HERTFORDSHIRE ECOLOGY

Your Ref: 6/2018/2768/OUTLINE
Ask for: M J Hicks
Tel: 01992 556158
Date: 19/07/2021

Application: Outline application for a large-scale mixed use development including 1,100 new homes and supporting infrastructure including a primary school, local centre and open space with all matters reserved
Address: Hatfield Business Park Hatfield AL10 9SL
Application No: 6/2018/2768/OUTLINE

C:\Users\k\Documents\working\leatnoos\bsg-ecology.com\332 Hatfield\Biodiversity impact plan.mxd

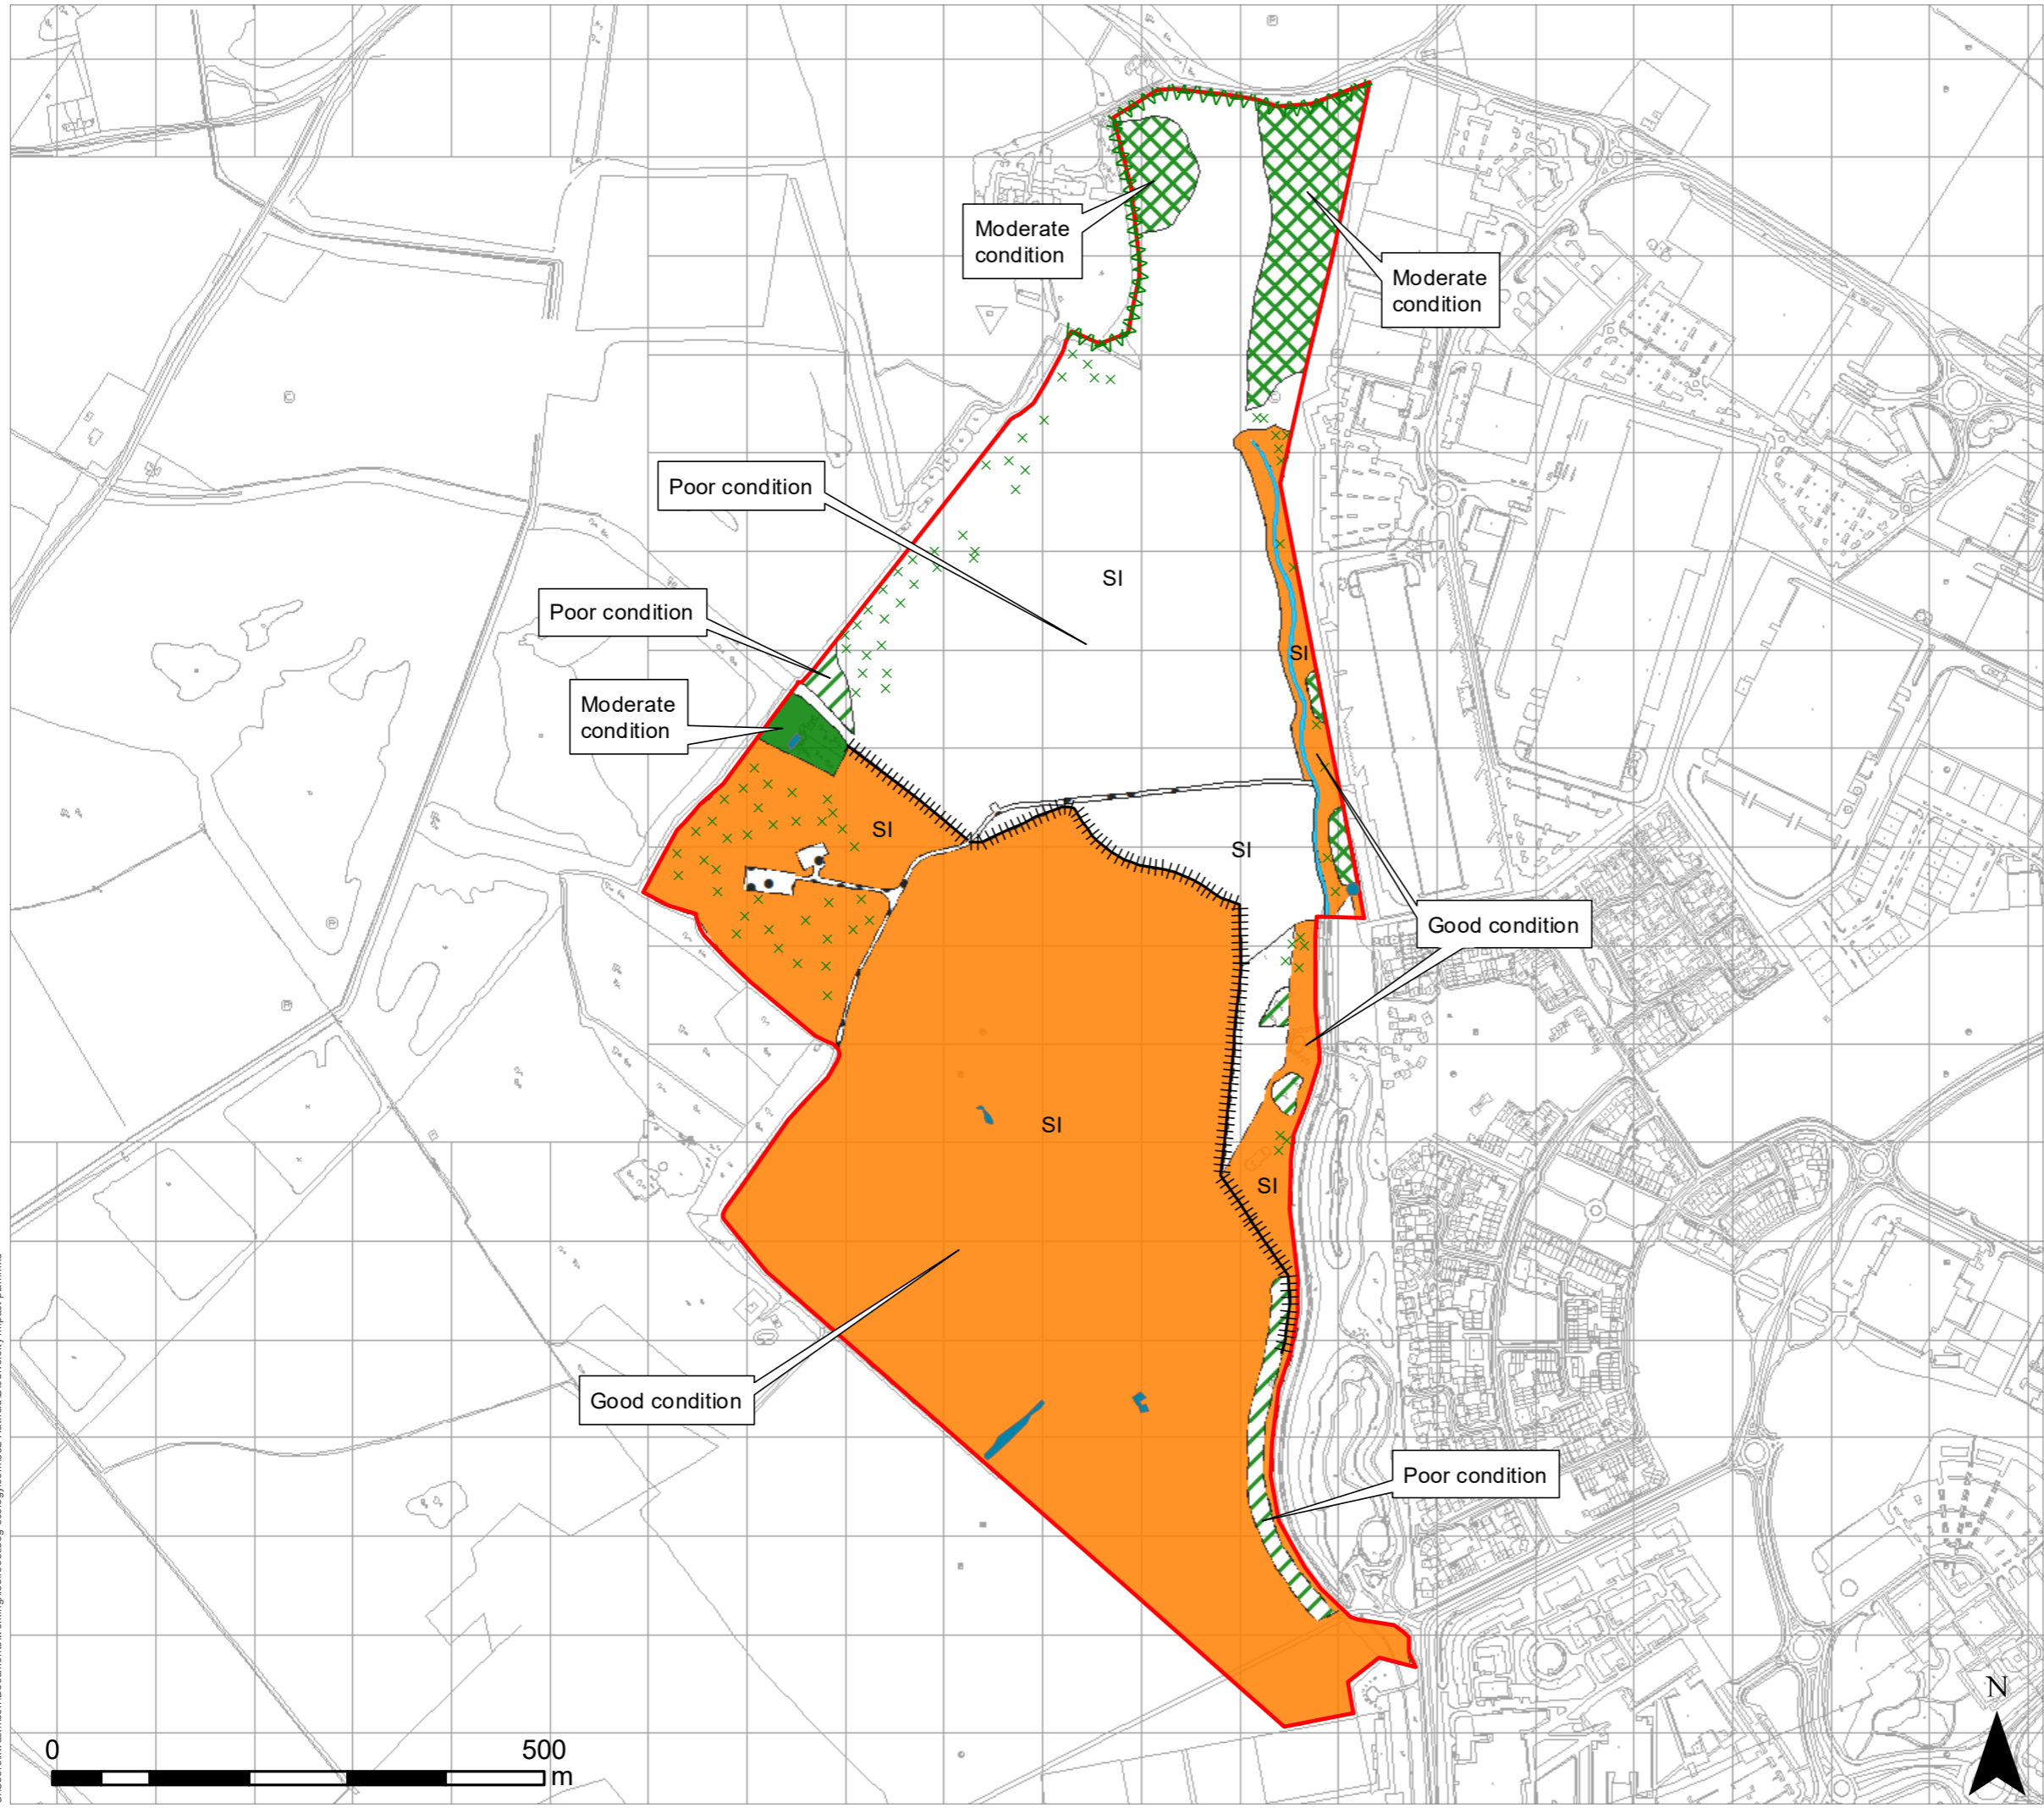
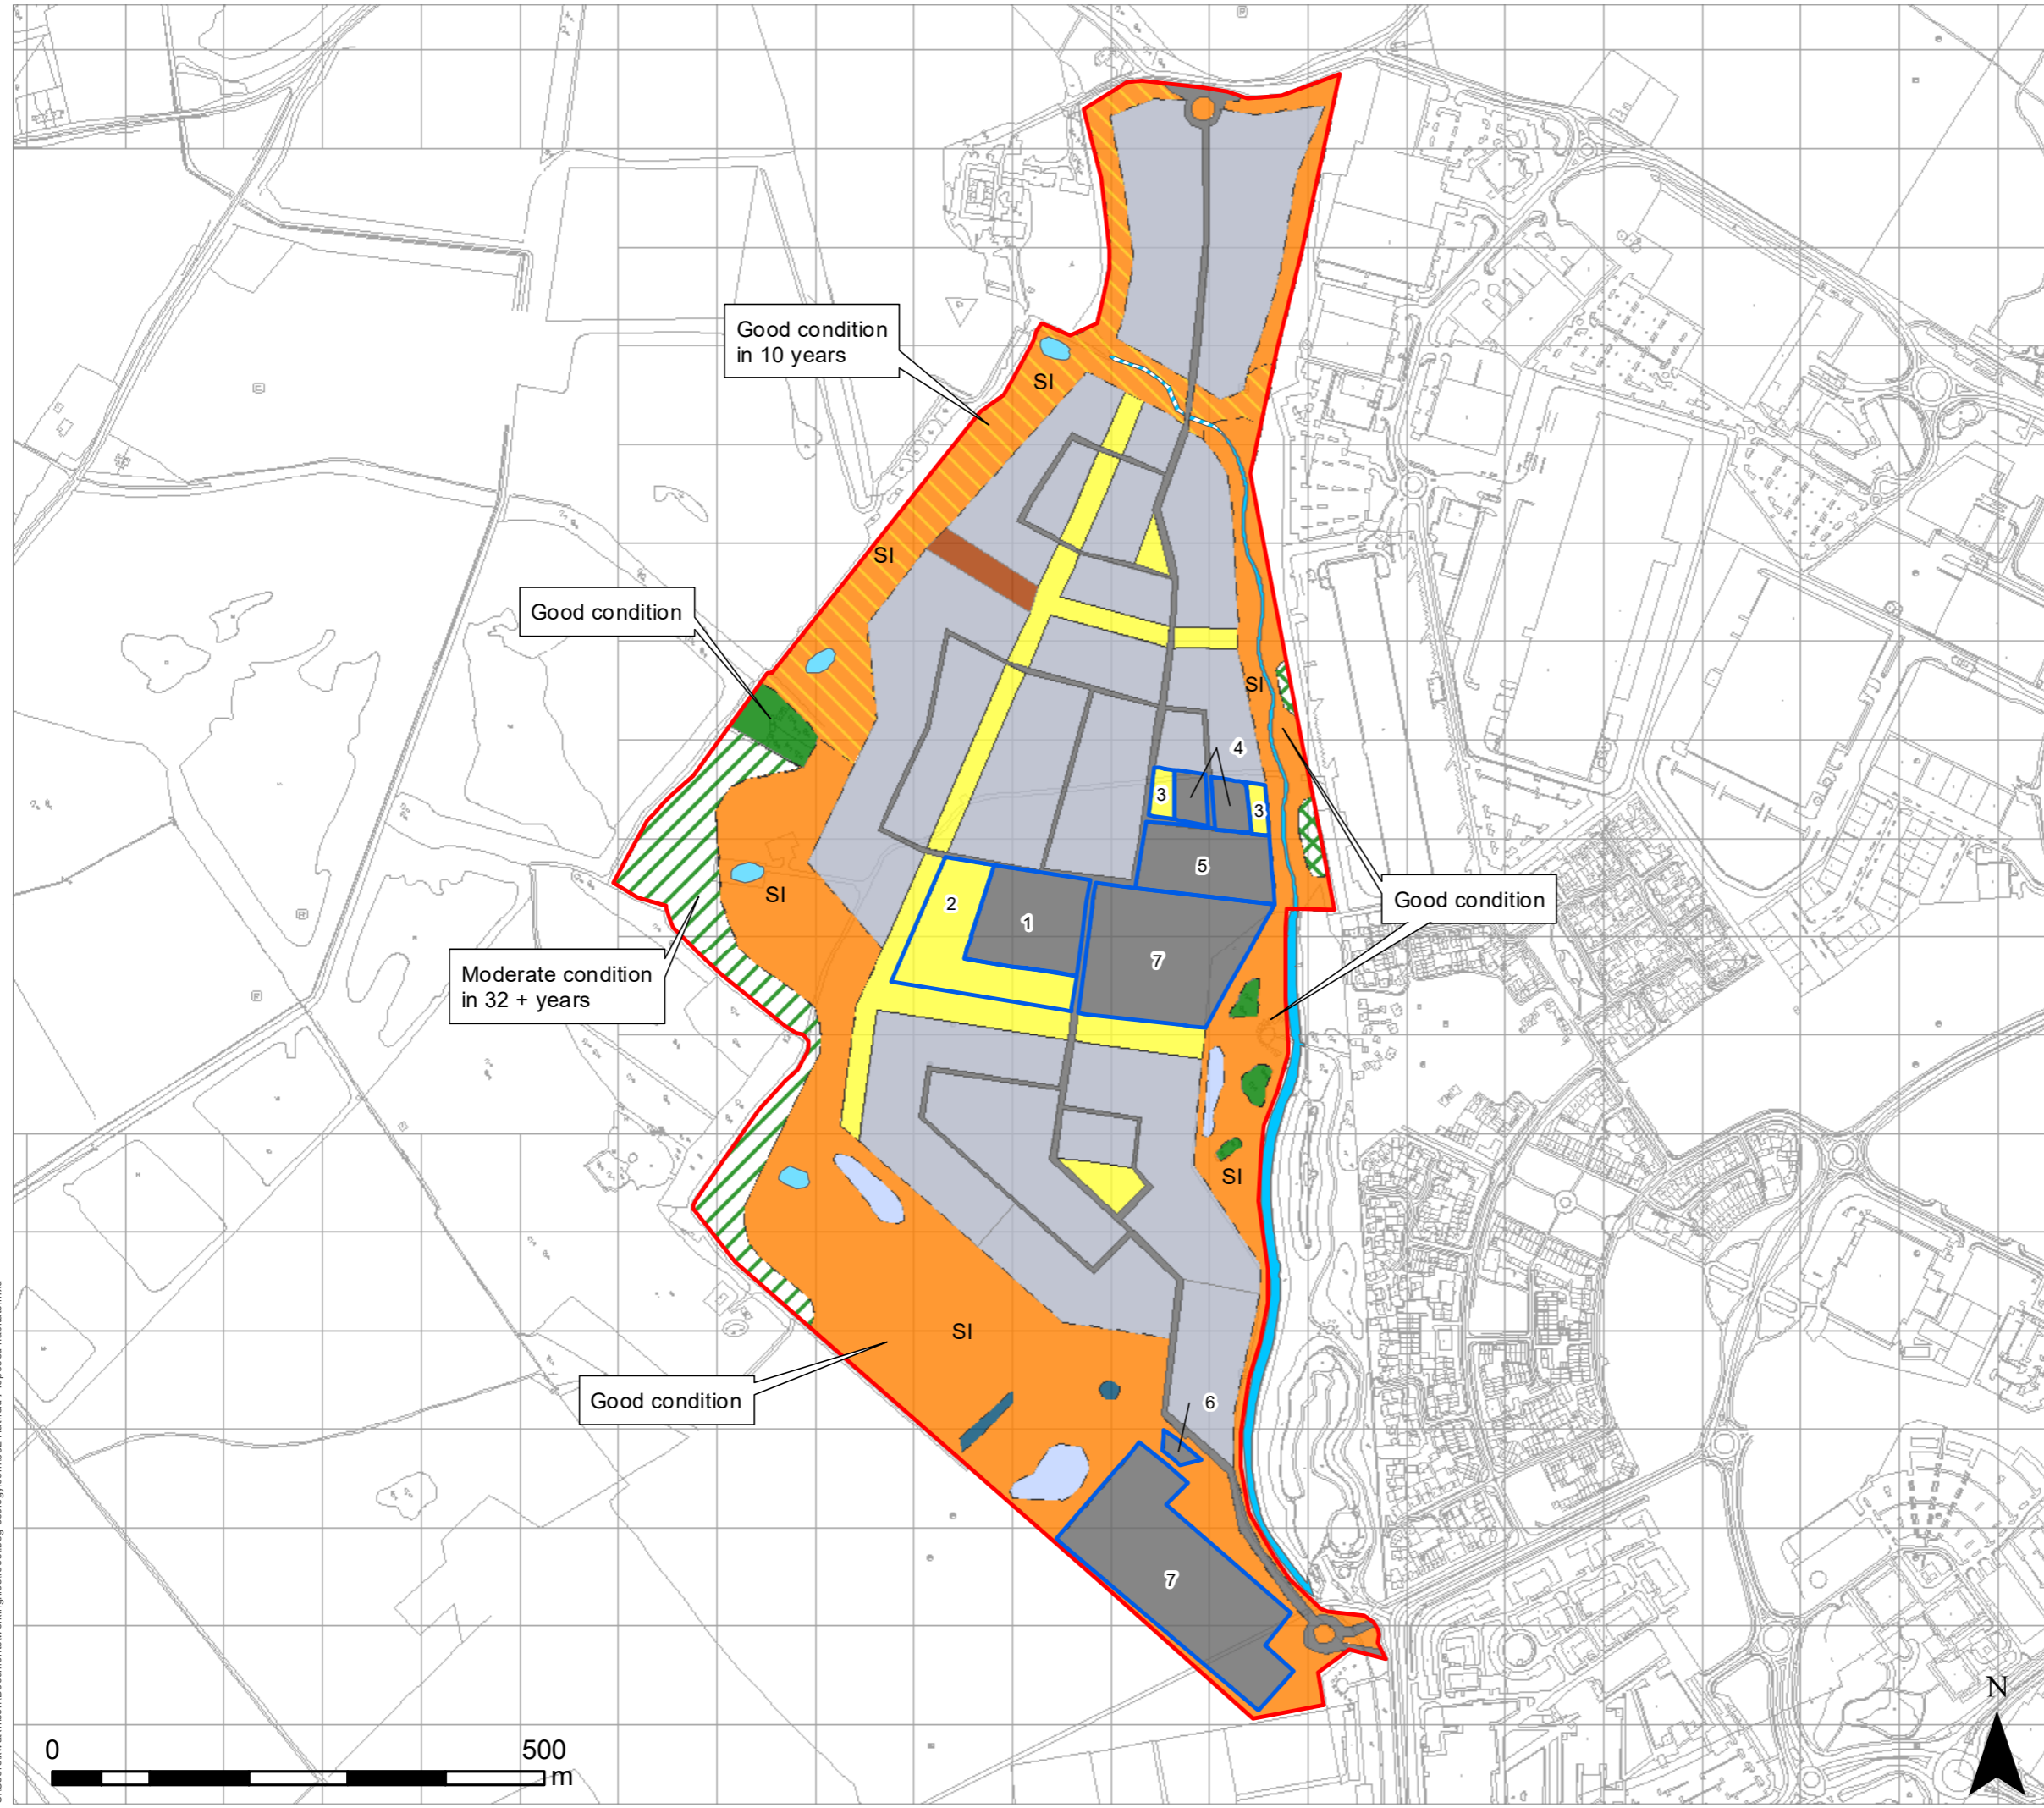
2. Whilst we note the Habitat Assumptions within the metric within Table A14.4-1, there is no submitted detail with on which we can provide an independent assessment, based upon the existing ecology survey and our own understanding of the site. Indeed, this information does not represent a metric, just its outputs; consequently, it is not possible to consider the basis for these assessments. Even here, we note that gardens and amenity grassland are included as contributing to future ecology which in practice is unreasonable given their functional use and inability to be subject to any legal agreement. However, we note that they are included within the NE metrics as contributing to potential biodiversity, which, nevertheless, cannot possibly compare with the existing ecological quality and quantity of the grassland resource to be lost.

3. The assessments are based on the habitat map Fig.A14.4 – 1. In this respect we note that over half of the site is considered to be species-rich semi-improved grassland, whilst the remainder is species-poor semi-improved grassland. Without seeing the full metric calculations, we cannot advise as to whether the proposed Unit loss has been calculated based on this assessment of distinctiveness and so has been properly considered, as there is no evidence as to how these figures have been derived.

6. Currently, if the proposals are approved there will be an anticipated net loss of biodiversity of essentially 350 credits (Biodiversity Units), taking into consideration an expected 10% enhancement of value of the site at the outset. This assumes the remaining (and proposed) grasslands can be secured and managed to achieve the desired quality, which in any event is questionable. However, this calculation cannot be adequately scrutinised as the metric details – and these grassland and other habitat scores - have not been provided.

12. On the basis of the above, I advise that the full metric is provided to enable proper scrutiny of its calculation. Without this, the LPA cannot assume the existing metric information is reliable, or that the result is an acceptable approach to any further development on this site, or that the proposals can be approved given the original intentions of the S106 Agreement if they are considered to remain reasonable and valid. I can provide further comments accordingly if the metric is provided.
